Albuquerque Bernalillo County Water Utility Authority

Development Facilitation Team (DFT) - Review Comments

DRB Project No: PR-2023-008423 Date: 04/05/2023 Agenda Item: #4 Zone Atlas Page: F-17 Legal

Application For: SI-2023-00606-SITE PLAN ADMINISTRATIVE (DFT)

**C04.1**

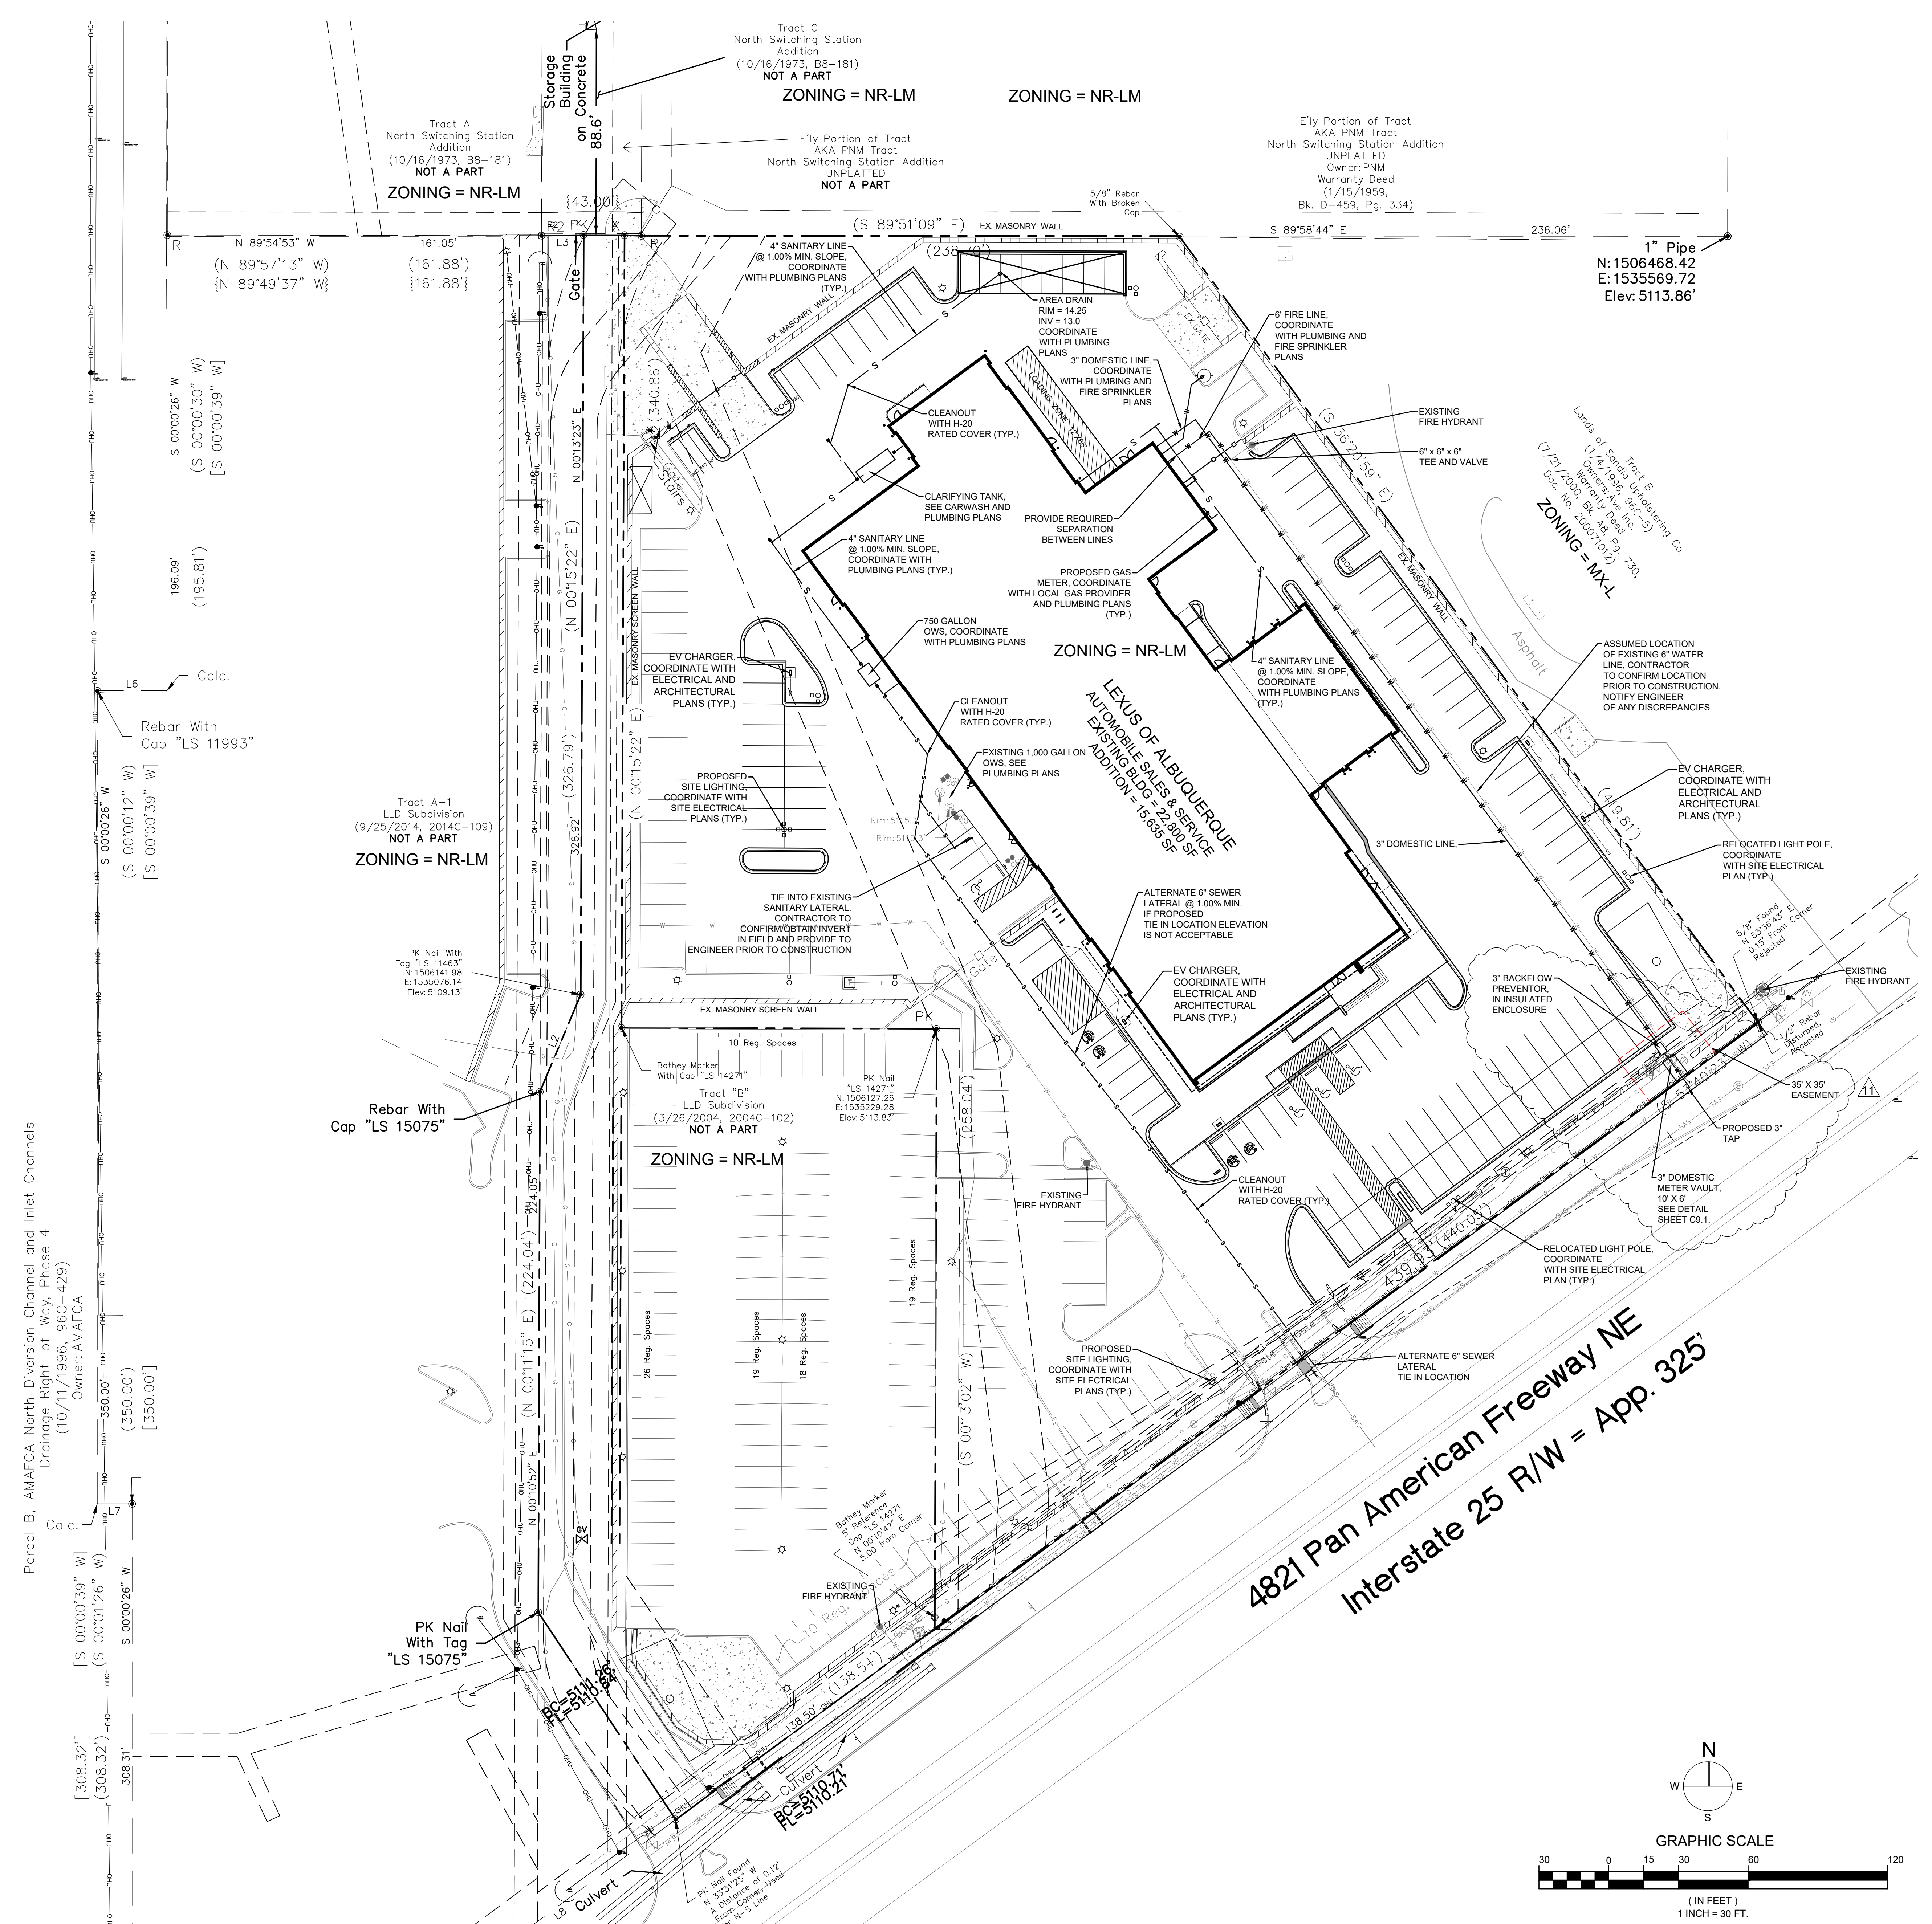
- a. Routine connection is available to the site however it appears no additional new connections are proposed.

RESPONSE: We propose to make a new water connection for the purpose of upsizing from the existing 2-inch to a proposed 3-inch meter and service line as shown on the Utility Plan.
